To: Charlotte Planning, Design & Development

From: Doug Lozner

Date of Review: September 27, 2021 (***Revised October 20, 2021***)

Rezoning Petition #: 21-130

**RZ1.0**

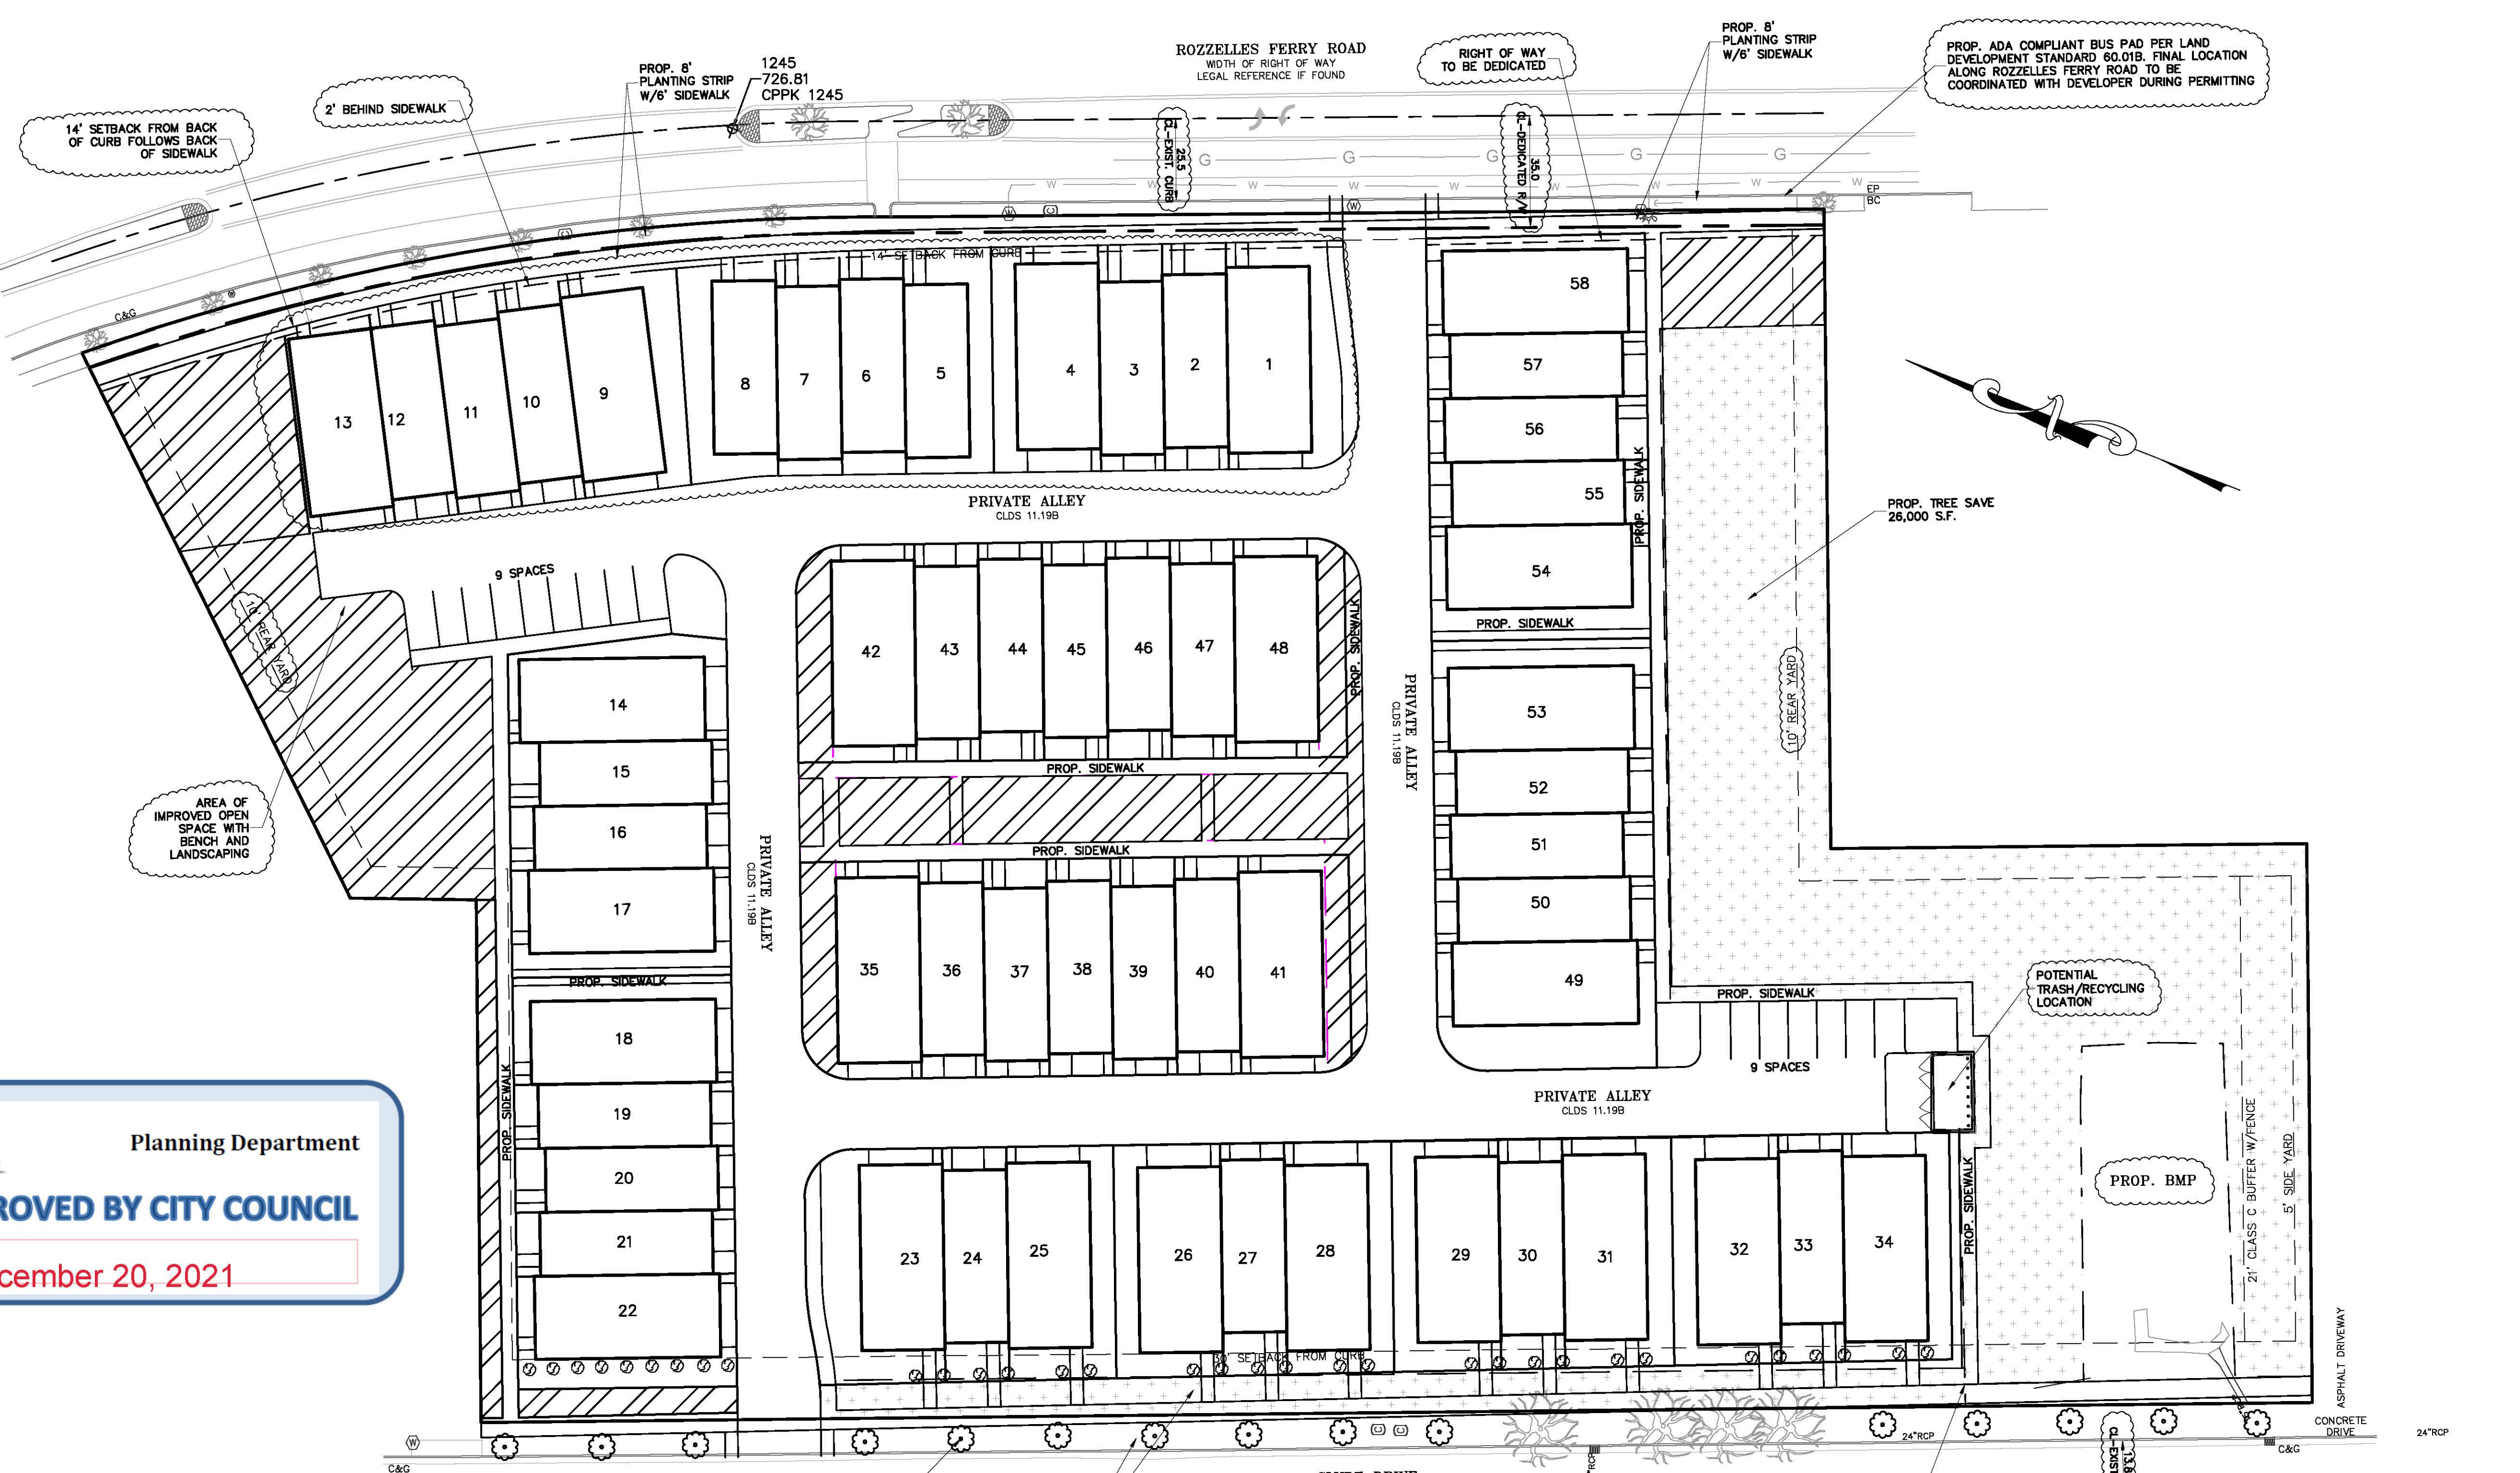
The proposed rezoning plan sheet indicates a proposed location for storm water management. Please include the following notes on the plan sheet under "Environmental Features": *The location, size, and type of storm water management systems depicted on the Rezoning Plan are subject to review and approval as part of the full development plan submittal and are not implicitly approved with this rezoning. Adjustments may be necessary in order to accommodate actual storm water treatment requirements and natural site discharge points.*

This property drains to the Irwin Creek, which is an impaired/degraded stream, and may contribute to downstream flooding. This project has the opportunity to mitigate future impacts to this stream, therefore, Storm Water recommends placing the following notes on the plan:

(I) Storm Water Quality Treatment

For defined watersheds greater than 24% built-upon area (BUA), construct water quality stormwater control measures (SCMs) designed for the runoff generated from the first 1-inch of rainfall for all new and redeveloped BUA associated with the project. SCMs must be designed and constructed in accordance with the Charlotte-Mecklenburg BMP Design Manual.

(II) Volume and Peak Control

For defined watersheds greater than 24% built-upon area, control the entire volume for the 1-year, 24-hour storm for all new and redeveloped BUA associated with the project. Runoff volume drawdown time shall be in accordance with the Charlotte-Mecklenburg BMP Design Manual.

For commercial projects with greater than 24% BUA, control the peak to not exceed the predevelopment runoff rates for the 10-yr, 6-hr storm and perform a downstream flood analysis to determine whether additional peak control is needed and if so, for what level of storm frequency, or if a downstream analysis is not performed, control the peak for the 10-yr and 25-yr, 6-hour storms.

For residential projects with greater than 24% BUA, control the peak to not exceed the predevelopment runoff rates for the 10-year and 25-year, 6-hour storms or perform a downstream analysis to determine whether peak control is needed, and if so, for what level of storm frequency.
